From: Tom Hastings <THastings@snopass.org>
Sent: Monday, November 4, 2024 8:19 AM
To: Bradley Gasawski
Subject: RE: SE-24-00032 Stoliarenko - Notice of Application

Thank you for the opportunity to comment during the Optional Determination of Nonsignificance process for the Stoliarenko Pedestrian Bridge. We have reviewed the documents and have the following comments.

Subject: SE-24-00032 – 24 Kearny Bridge
SR 906 MP 0.98 Lt Vicinity

SUBJECT: WDFW COMMENTS ON SE-24-00032 Stoliarenko

BRIDGE PLAN

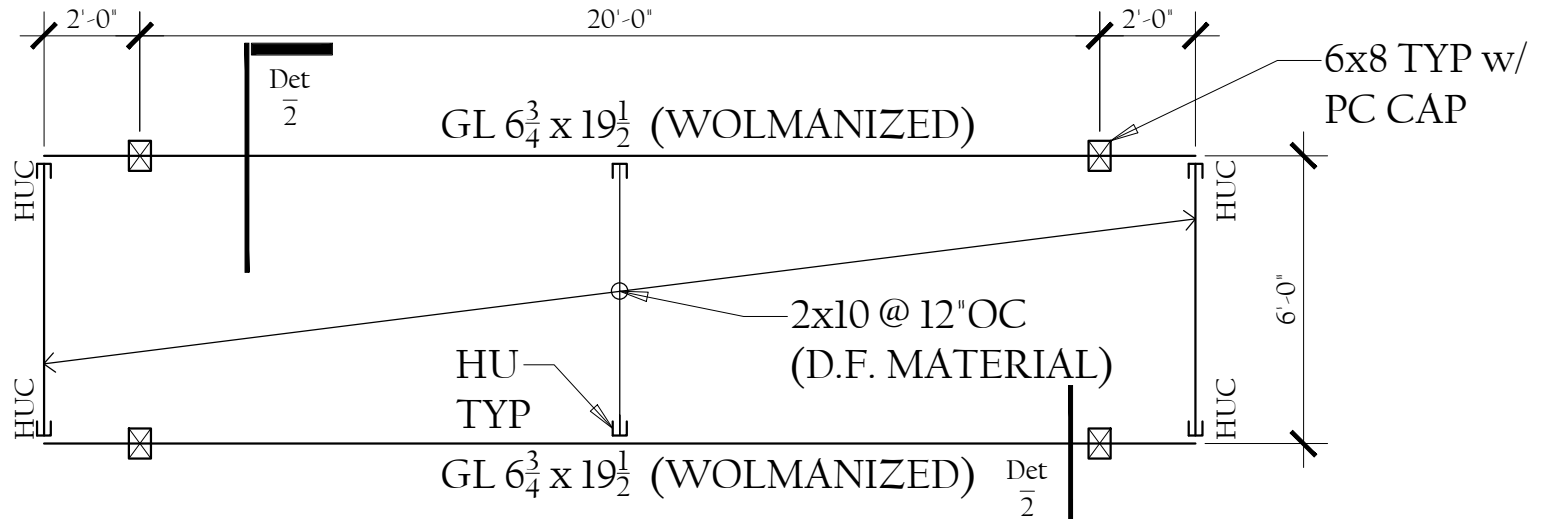
Brad
comments from the District:
I do not see property lines on the Bridge Plan View. The District is concerned as there is water and sewer lines in the utility easement in front of the lot. The District needs more info about where the bridge and retaining wall will be placed to ensure that these structures are not placed in the utility easement. If the retaining wall and bridge are outside if the utility easement, then the District has no comment.
